Your ref: N6/2010/2055/MA
Our ref: E/WH/2010/22105/N/340

FULL PLANNING PERMISSION FOR PART DEMOLITION, REPAIR, RESTORATION, EXTENSION AND CONVERSION OF THE FORMER SHREDDED WHEAT FACTORY COMPLEX TO PROVIDE RETAIL (A1 & A3), BUSINESS (B1), HERITAGE CENTRE (D1), ENERGY CENTRE, NEW LEISURE CENTRE BUILDING AND CIVIC SQUARE BUILDING INCLUDING RESIDENTIAL AND RETAIL (A1 TO A5). ASSOCIATED ALTERATIONS TO EXISTING VEHICULAR AND PEDESTRIAN ACCESS AND HIGHWAY LAYOUT WITHIN AND AROUND THE SITE, INCLUDING THE CREATION OF TWO VEHICULAR ACCESS RAMPS TO BASEMENT PARKING, HARD AND SOFT LANDSCAPING, THE PROVISION OF A CIVIC SQUARE, PARK, PUBLIC AND PRIVATE OPEN SPACE, PEDESTRIAN WALKWAYS TO INCLUDE THE UPGRADE OF THE EXISTING PEDESTRIAN FOOTPATH OVER THE RAILWAY LINE AND ASSOCIATED ENABLING WORKS. OUTLINE PLANNING PERMISSION FOR DEVELOPMENT OF LAND TO THE WEST AND SOUTH OF THE SHREDDED WHEAT FACTORY TO COMPRISE THE FOLLOWING USES: RETAIL (A1 & A5), BUSINESS (B1), HOTEL (C1), RESIDENTIAL, TO INCLUDE: HOUSES, FLATS, CARE HOME AND YMCA (C2 & C3); DOCTORS SURGERY AND PHARMACY (D1); WITH ALL MATTERS RESERVED APART FROM MEANS OF ACCESS - FORMER SHREDDED WHEAT FACTORY COMPLEX AND LAND ADJOINING, ROADWATER

FIRST FLOOR PLAN

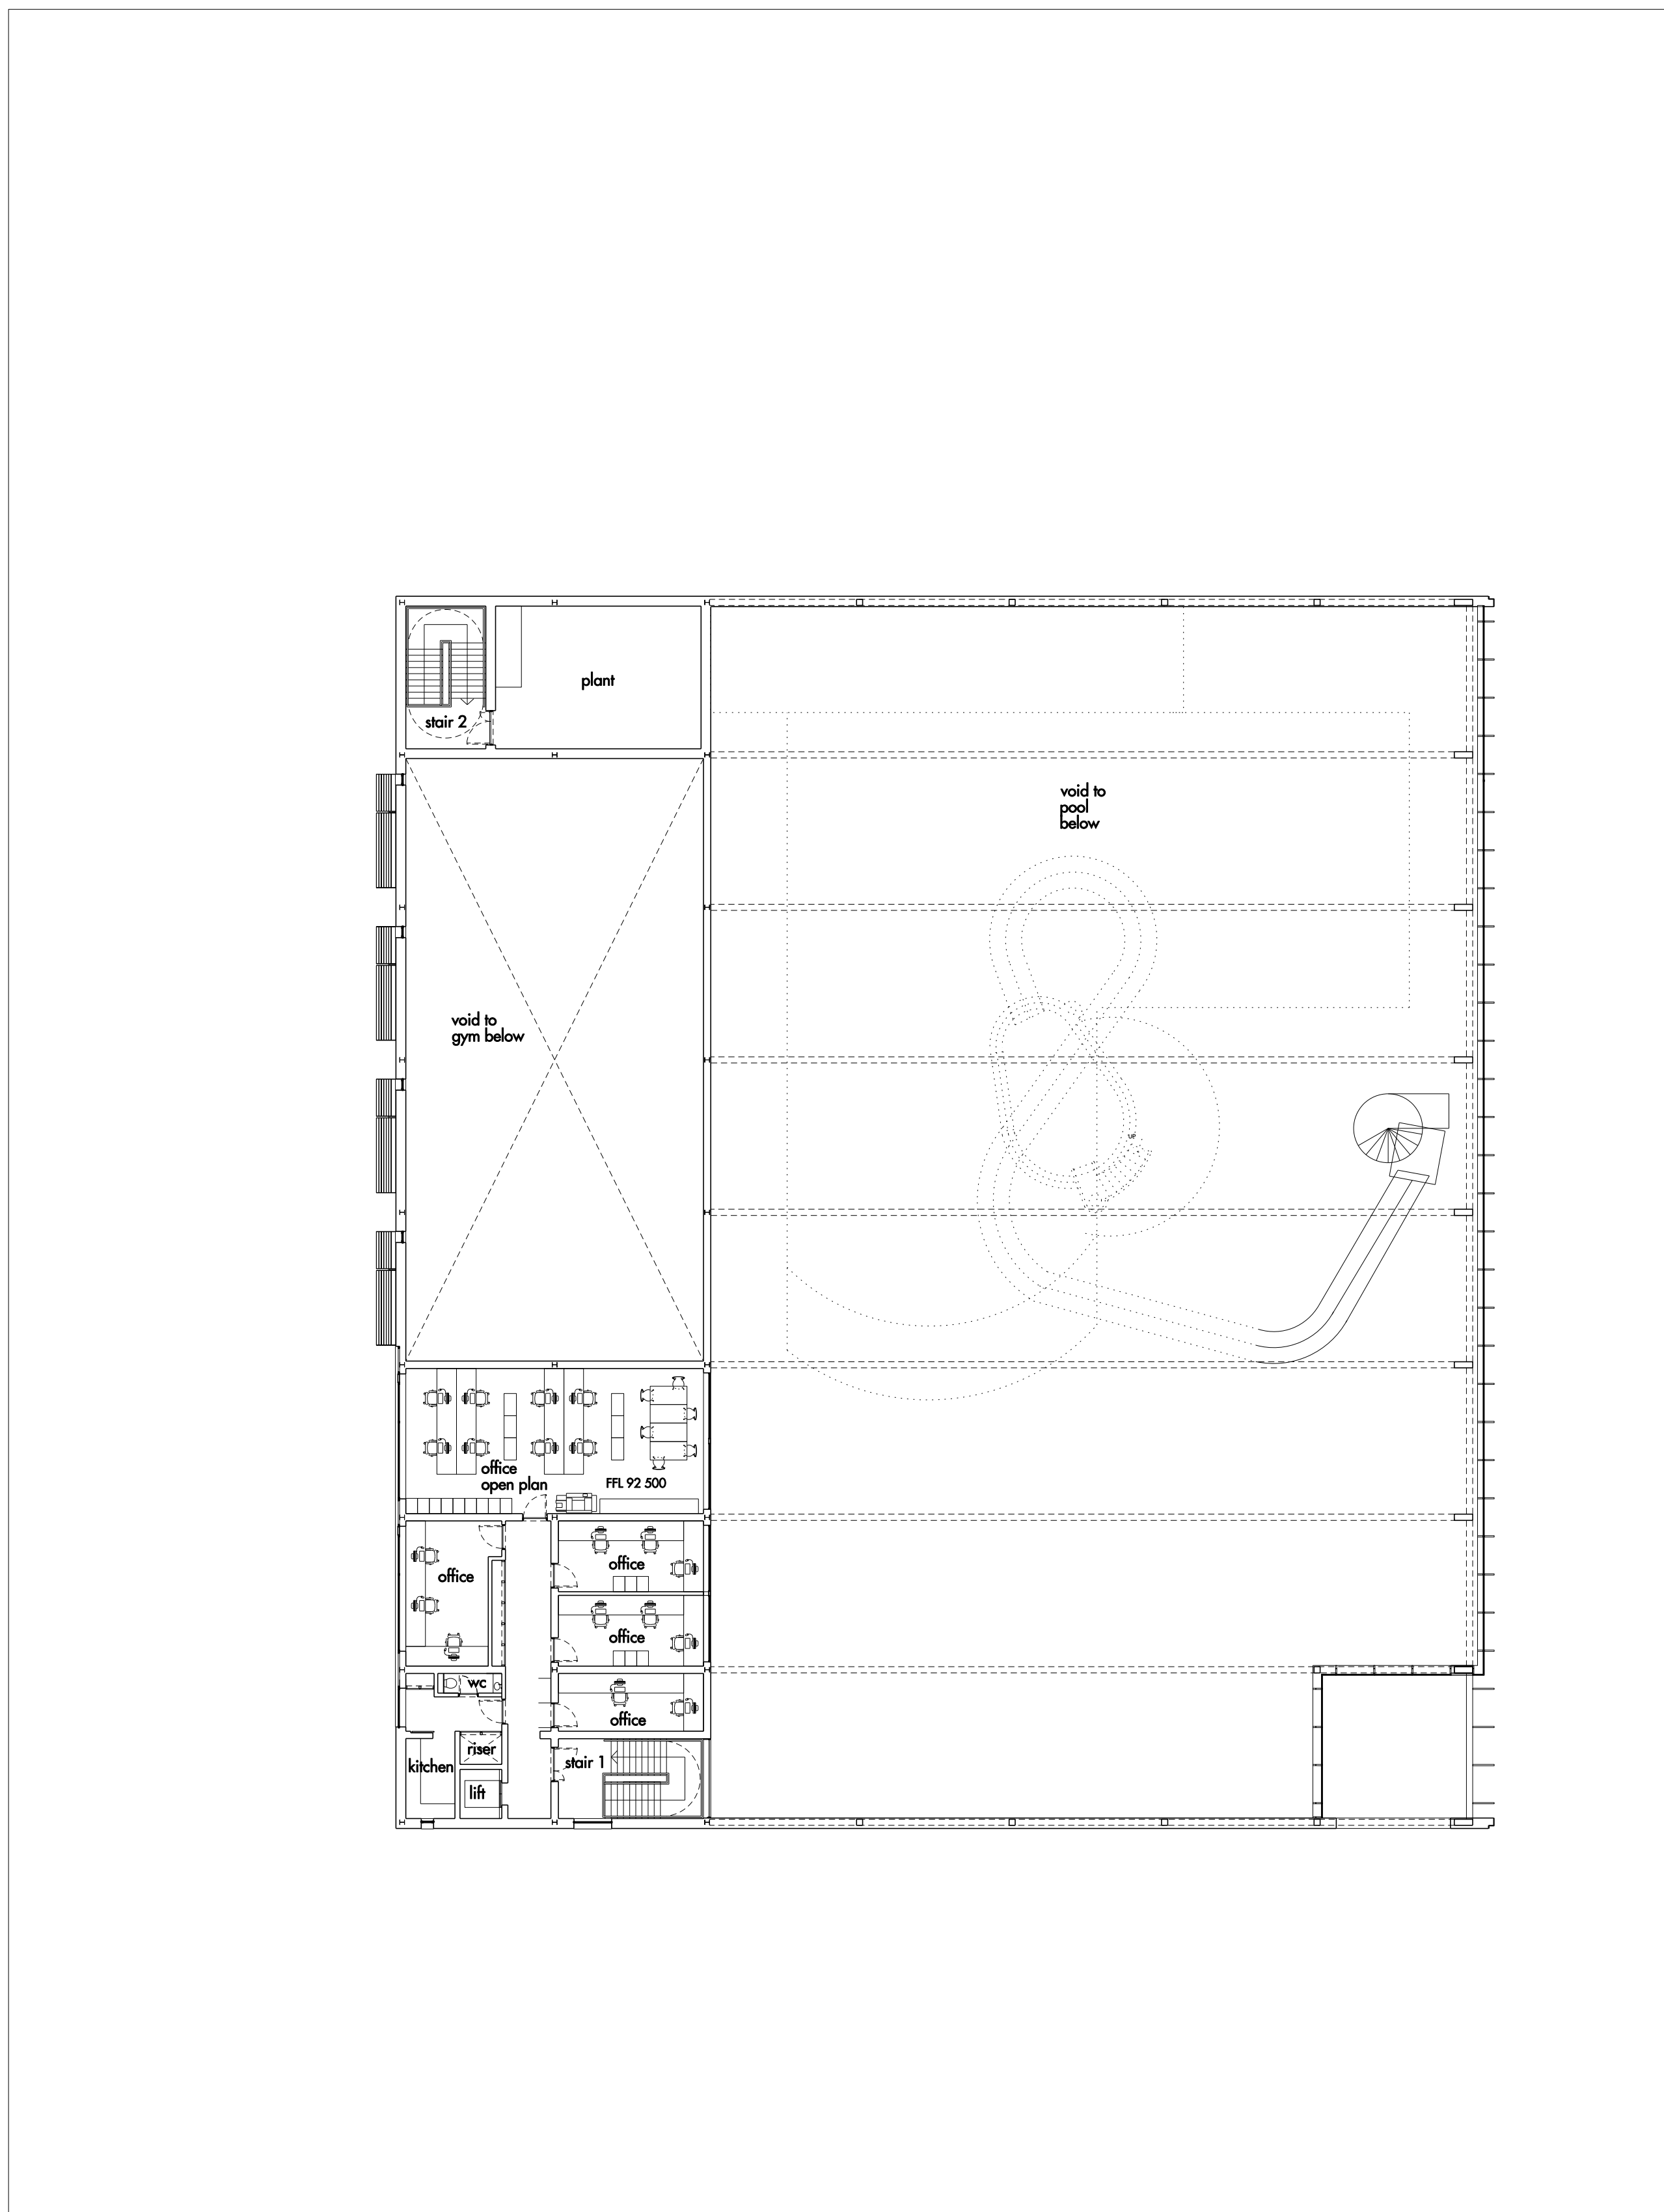
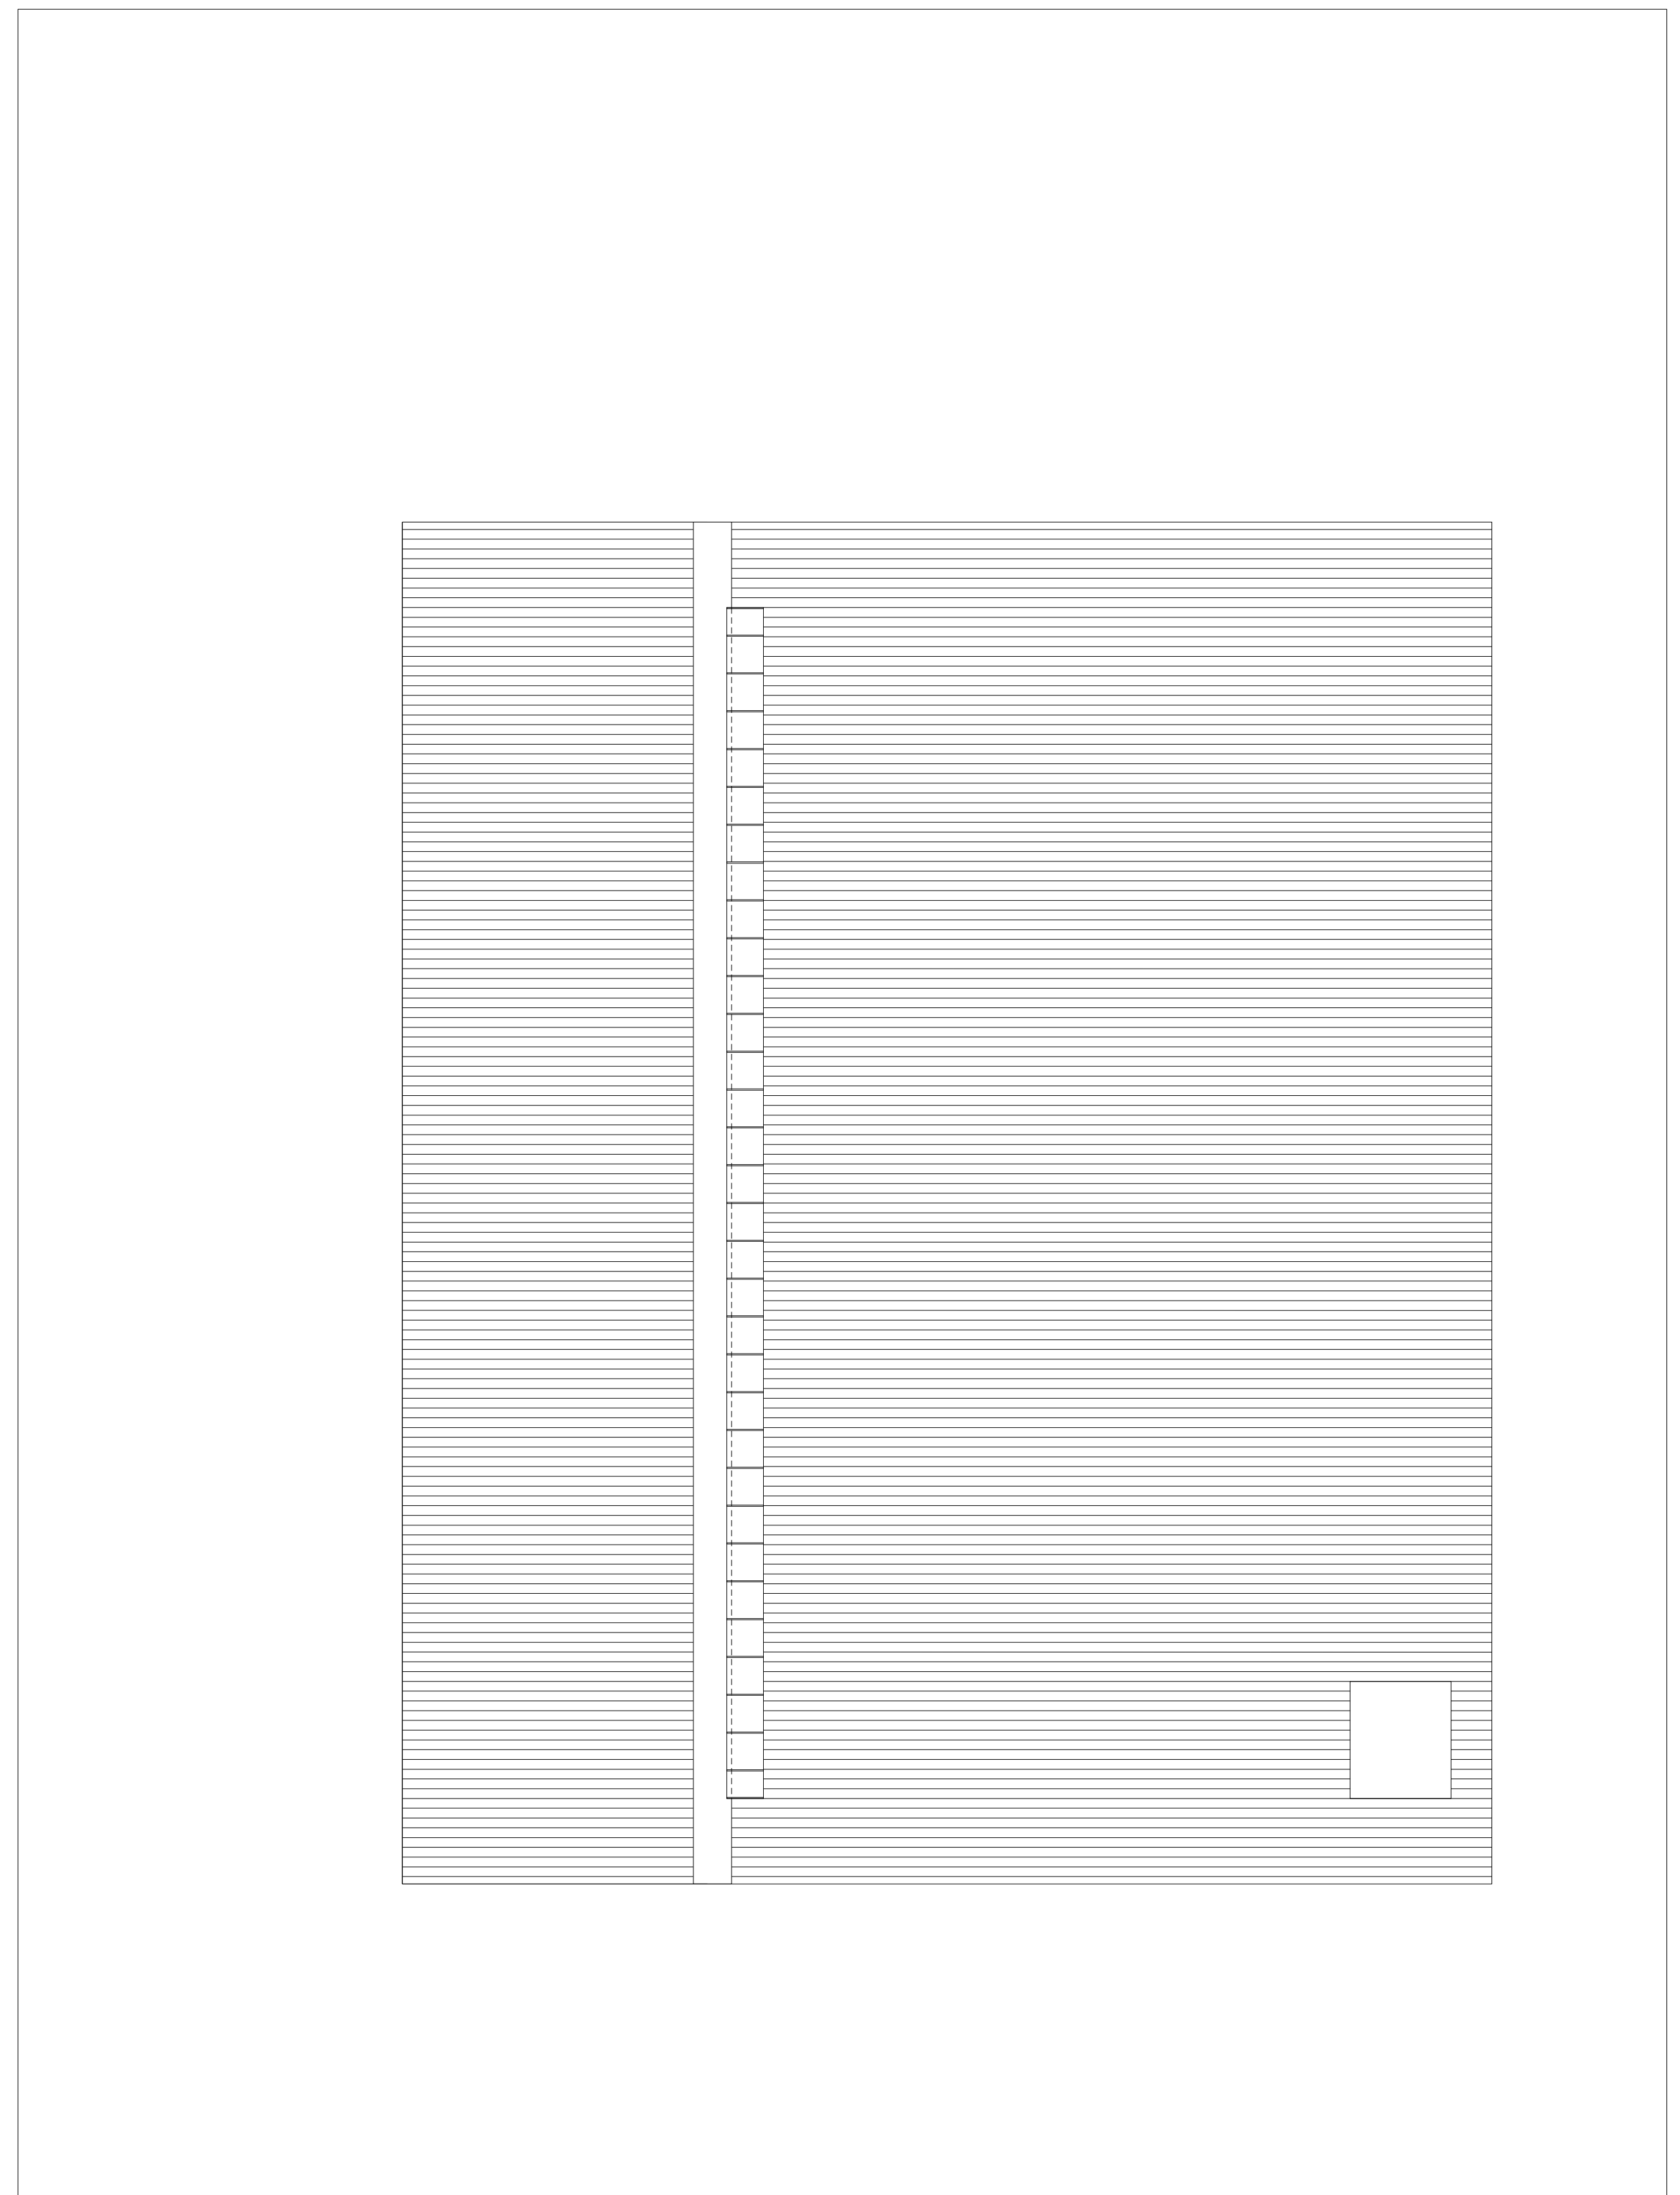
- Sport England promote the use of a draft lobby at the main entrance to aid the reception environment.
- The turnstiles would normally be post reception, in order to allow access to the reception whilst also maintaining control of access to the building
- It is recommended that the first aid room has a direct exit to the outside so that a casualty can be loaded directly into the ambulance. This would require a change of location.

- The pool is currently designed to accommodate both lane and leisure swimming – does this reflect local need? Can the pool deliver on the learn to swim priorities that may be required locally through educational need and community need with the current design?

- If the swimming pool is to remain as proposed it is suggested that the swimming pools would benefit from being the other way round i.e. with the 25m run being parallel to the changing rooms (shallow end at the entrance end). This will allow people that bring other people to learn to swim classes to be able to observe what is happening from the seating in the café area.

- In relation to the 25m section of the pool the flume should be moved so it does not go over this at all (it is thought that there is room to achieve this) and the raised section (labelled events) at the deep end should remain at a similar level (deck level) all around the swimming pool – both of these points relate to access and sight lines for staff, particularly when the swimming pool is in use for club/teaching, when good contact between staff on the poolside and those in the water is required

- The proposed width of the 25m section of the pool is 12m. Sport England's Swimming Pool Design guidance document (referenced above) recommends that the width of a 6 lane pool should be 13 metres wide while the width of a 5 lane pool should be 10.5 metres

- It would appear that spectators are encouraged to be on poolside and use toilets that lead from the pool surround. It can not be understood from the detail provided how these areas are separated (if at all) but this would encourage contamination, as would the food serving area, into the wet side if not carefully managed

- Changing spaces – the current level of provision is 94 plus group change. Based on the volume of water space provided approximately 190 change spaces are needed to cope with average demand. This is based on the calculation model identified in the guidance (link provided above). This needs to be considered alongside the programming of the facility to feel confident that any final proposals can accommodate user numbers.

- Toilets - In terms of toilet provision, the current level of provision is 13 WC's and 6 urinals. For the amount of water space proposed 10 WC's and 6 urinals are required.

- Showers – currently 17 are provided, this could be rationalised to 12 to 14. It is recommended that all showers are provided in central areas and not within toilet areas. This means that they

are accessible by all. It is advantageous to provide some of the showers are cubicle showers to aid privacy. Showers should be centrally located to facilitate both pre and post swim usage.

- An accessible change is required in wet side area.

- An accessible change is required in dry side and not just a toilet.
- In terms of layout this is not ideal. The toilets should be accessed first. This allows those users who are not getting changed to access the toilets. This then leads to the change area with showers at the rear. With the current proposed layout anyone wishing to use the toilet will have to access the change

- In terms of capacity, the usable space in each is around 34 (this is presuming that each square within the changing rooms on plan Detailed Proposals: Leisure Centre (Building A) Proposed Plans (568_07_210) are changing spaces as apposed to lockers). 1 change space per gym station or 1 change space per 5 sqm of gym floor space are the recommended ratios. The proposed dry side changing areas therefore currently represent an over provision

- There are currently 6 showers proposed. 1 shower per 6 change spaces is the recommended ratio. The proposed provision of showers therefore currently represents an under provision (as mentioned above, this is presuming that each square within the changing rooms are changing spaces as apposed to lockers)

- Lockers – these can be provided within the change area or outside. It is recommended to provide small valuables lockers externally to facilitate those not using the change area. Lockers should not be provided behind the changing spaces as this compromises access at peak time. There should be 2.5 lockers per change space to allow for change overs and a number of lockers being out of use. Accessible lockers need to be provided outside of the accessible change

- Natural light should be encouraged whilst avoiding glare
- Views over the pool should be included where appropriate (whilst being aware of child protection issues)
- A plumbed in water fountain should be included to serve the gym

- The toilet located on the second floor needs to be accessible

- There is significant office space on the second floor. This may be useful for centre and local club usage but this needs to be clarified as it is a significant expense to the scheme.
- In relation to the long term sustainability of the proposed Leisure Centre to may be useful to consider the mixture of facilities included i.e. would the inclusion of a larger gym or a dance studio be beneficial from a revenue generation perspective?
